Planning Officer: Mr S Davis

Planning Application Ref: BR/55/20/PL

Location: Abbots Lawn, Sylvan Way, Bognor Regis, PO21 2RS

Description of works: Proposed first and second floor extensions

block plan

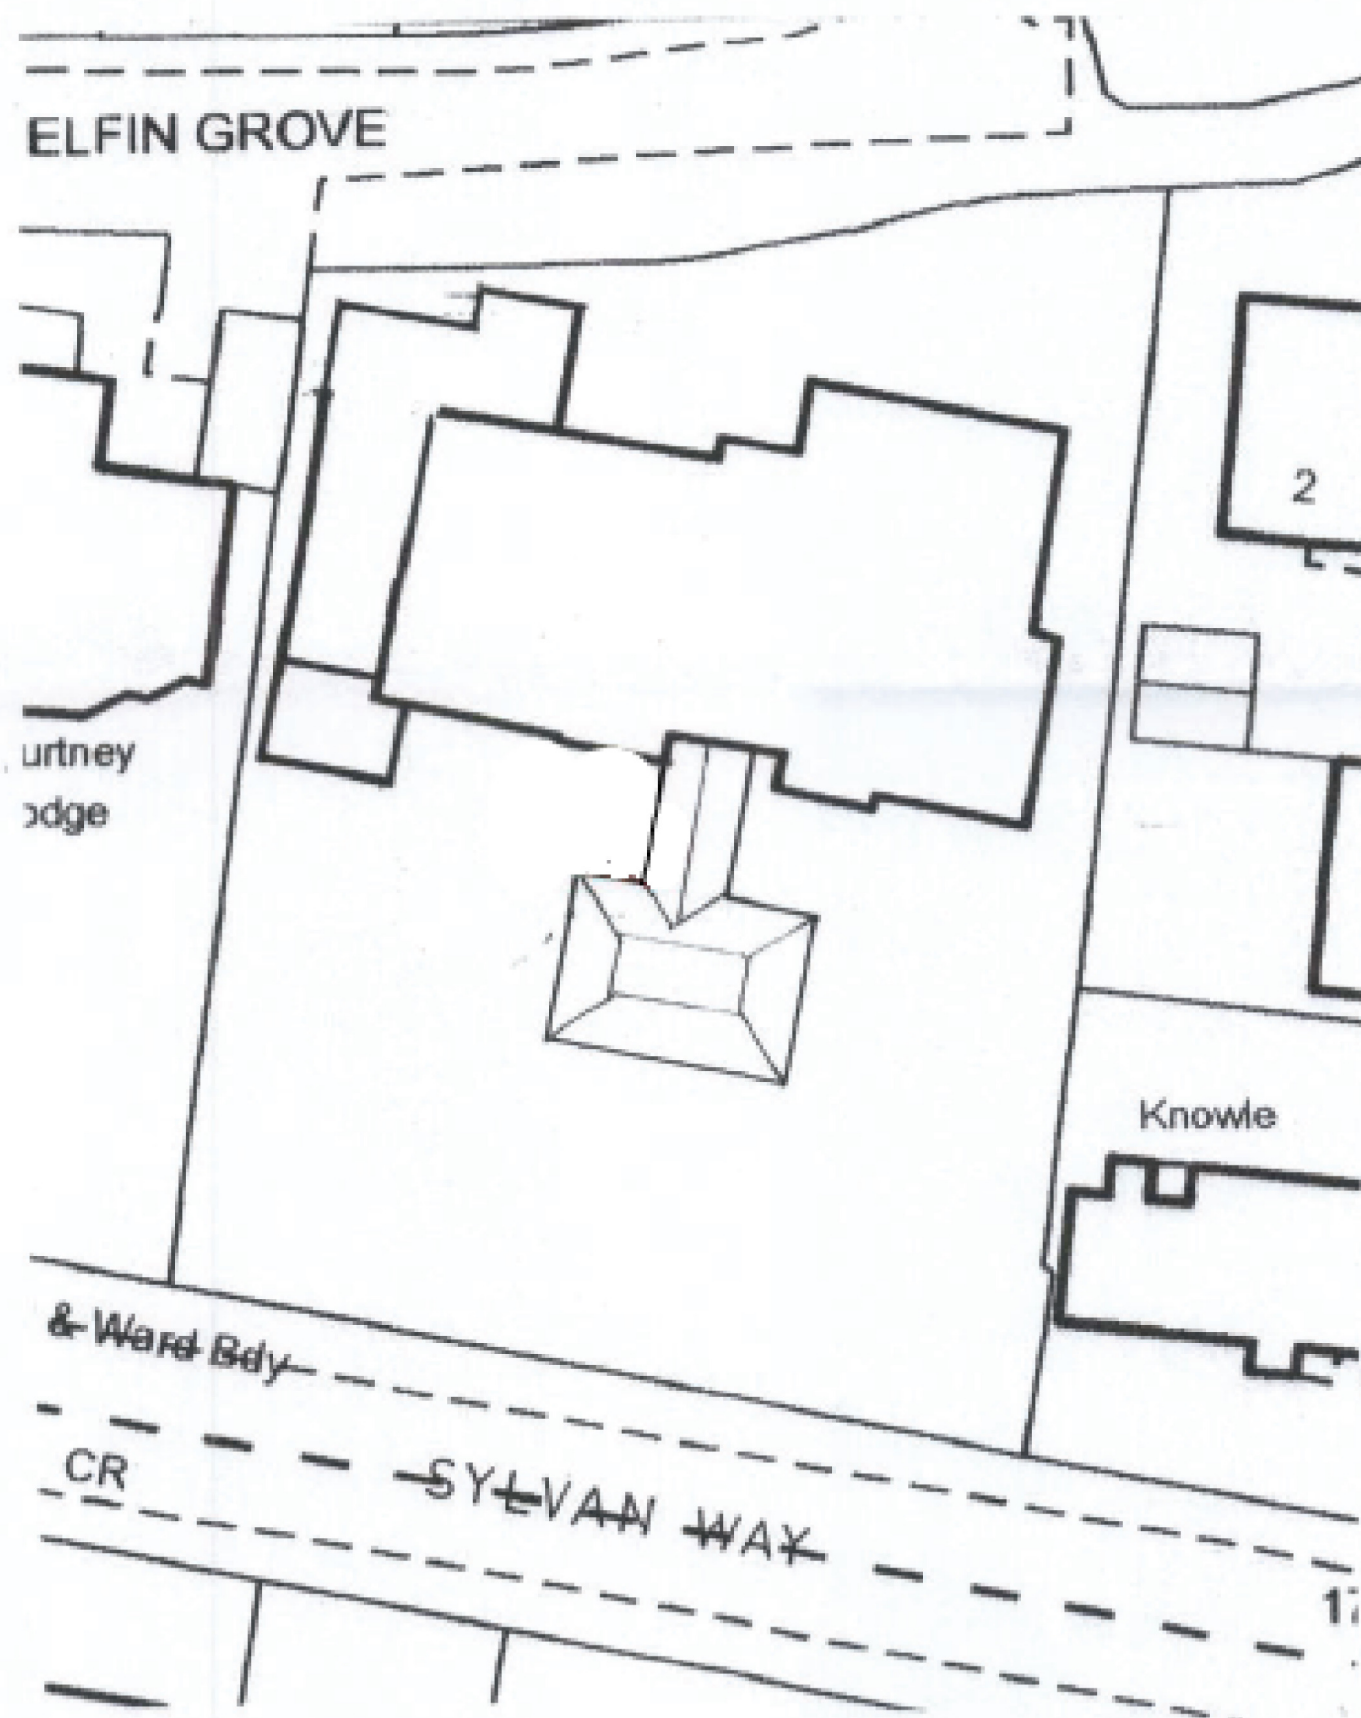
- The introduction of two new parking bays on the west boundary is to my mind problematic for two reasons. Firstly, it seems there would have to be some excavation in order to tie-in with the 'No-dig' (enhanced) driveway which would undoubtedly involve the loss of root material (fibrous and potentially those of structural importance). Secondly, those cars would be parked beneath the canopy spread of two large trees with a known propensity to deposit 'honeydew' – a sticky secretion from aphids that can be damaging to car paintwork if not removed promptly.

Option 1 – The parking bays (x2) along the west boundary are abandoned and the shrub border left intact. More detail of ground protection measures and extent of 'No-dig construction' to be clearly illustrated on the TPP. Civil engineering exercise to be provided, demonstrating viability of 'No-dig construction'.
